Application for Planning Permission for Works or Extension to a Dwelling

Development: Removal of existing conservatory and erection of single storey rear extension.
Location: 6 Glynde Close Ferring BN12 5BJ

Proposed Front (South-West) Elevation

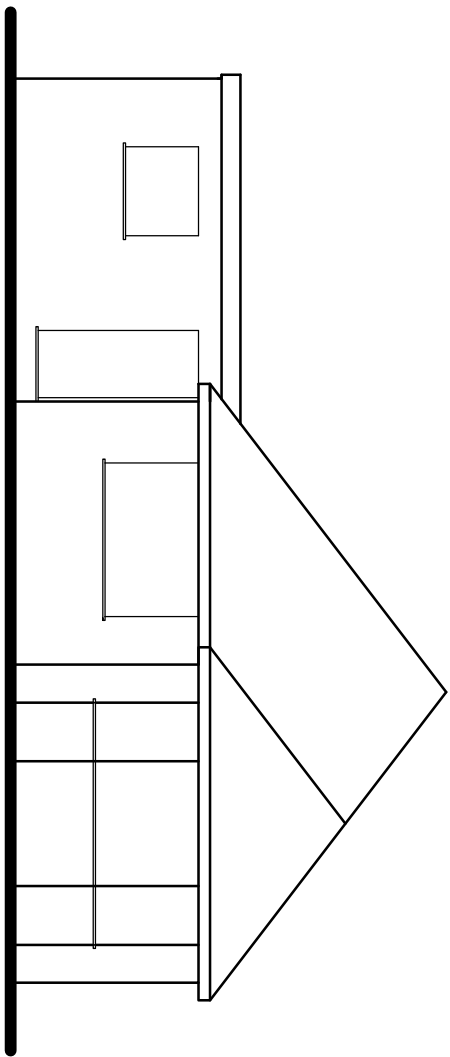
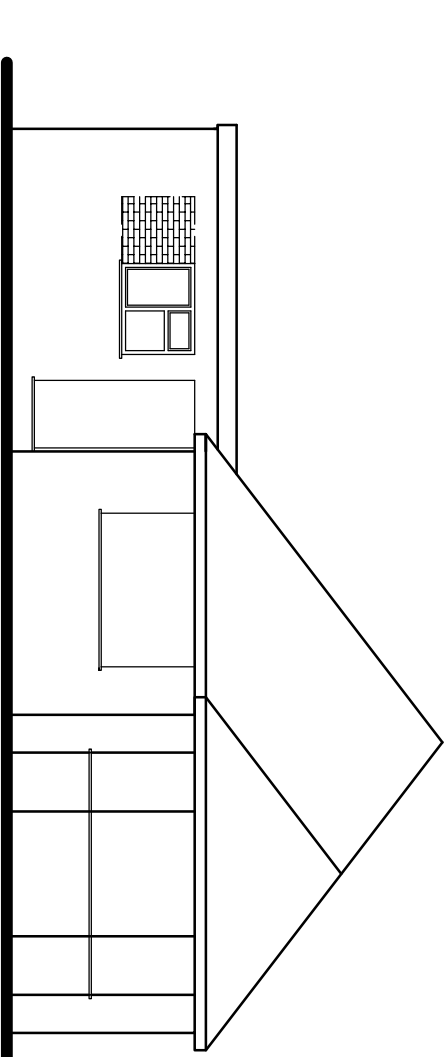
Front Elevations

Please submit electronic plans in pdf format clearly labelled existing and proposed front elevations at a scale of 1:50 or 1:100. Further details can be found in the Validation Requirements List.
